6 November 2013

Re: Application No: MP07_0158 MOD 3 - Objection to Modification Request for the University of Sydney Abercrombie Precinct Redevelopment – Proposed Student Housing Building

Sheridan Planning (**SP**) is acting on behalf of Mandelbaum House, a residential college which adjoins the site of the proposed Student Housing Building on the Abercrombie Precinct at the southern end of the Darlington Campus, University of Sydney. **SP** has been engaged to review the above modification application and prepare a submission to the Department on behalf of Mandelbaum House.

Ground Floor Plan
1:200@A1
11.10.13
4001_DA02-D

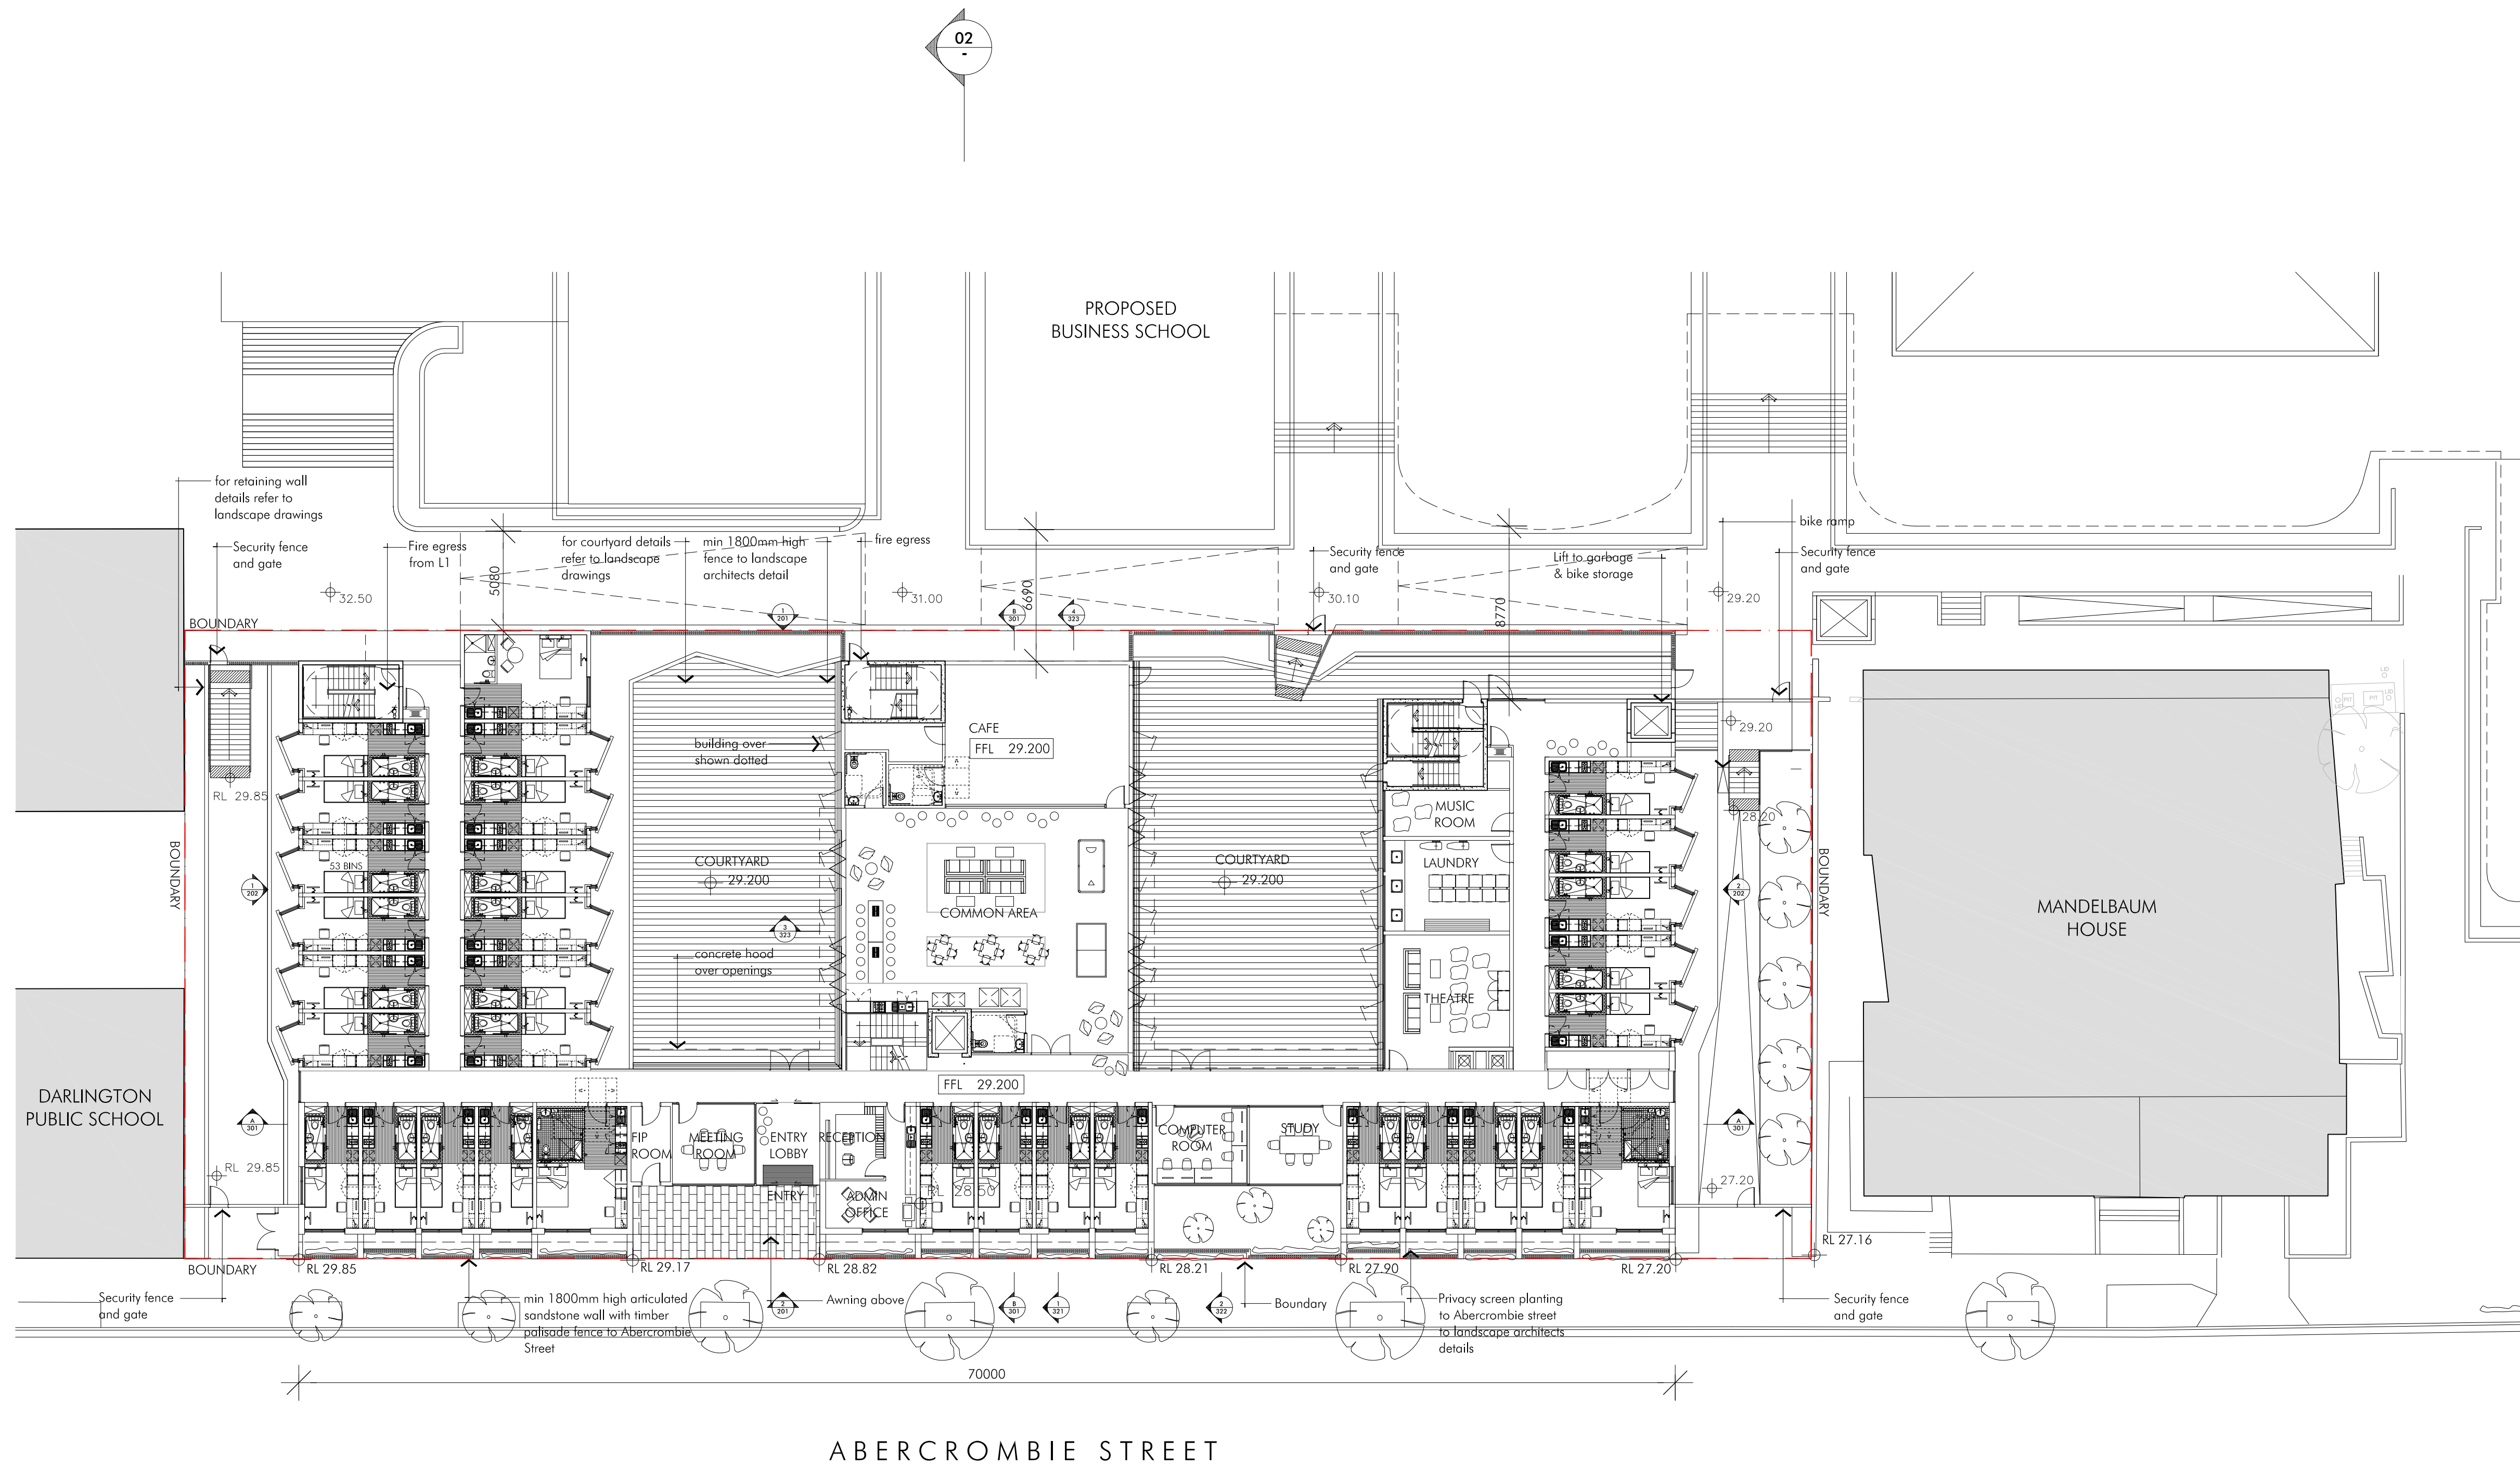
The nil setback proposed for the Student Housing Building is considered to be inadequate and coupled with the excessive height of the development will have significant visual impacts on the streetscape. It is our view that the proposed development should be consistent with the established setback in this location, and therefore should be set back from the front boundary by 2 metres, which would be in line with Mandelbaum House.

The proposal has the potential for pedestrians to walk along the side setback of the new Student Housing Building running from Abercrombie Street through to the university campus at the rear. There has never been pedestrian access between Mandelbaum House and the site of the proposed New Student Housing Building. Mandelbaum House needs to maintain this buffer for its continued security as both a place of residence and a Jewish institution where heightened security concerns are critical. A pathway makes the College vulnerable.

It is our view that pedestrian access adjacent to Mandelbaum House should be restricted due to potential noise and security issues adjacent to Mandelbaum House's bedrooms and common areas.

- The building should be set back approximately 2 metres to align with Mandelbaum House along its Abercrombie Street frontage.
- Trees should be planted within the 2 metre setback along the front to assist in visually screening the proposed new buildings to allow for greater privacy and increased streetscape amenity.

- Pedestrian access along the eastern side setback adjacent to Mandelbaum House should be restricted and dense landscaping along the side boundaries should be planted to provide privacy and visual amenity.
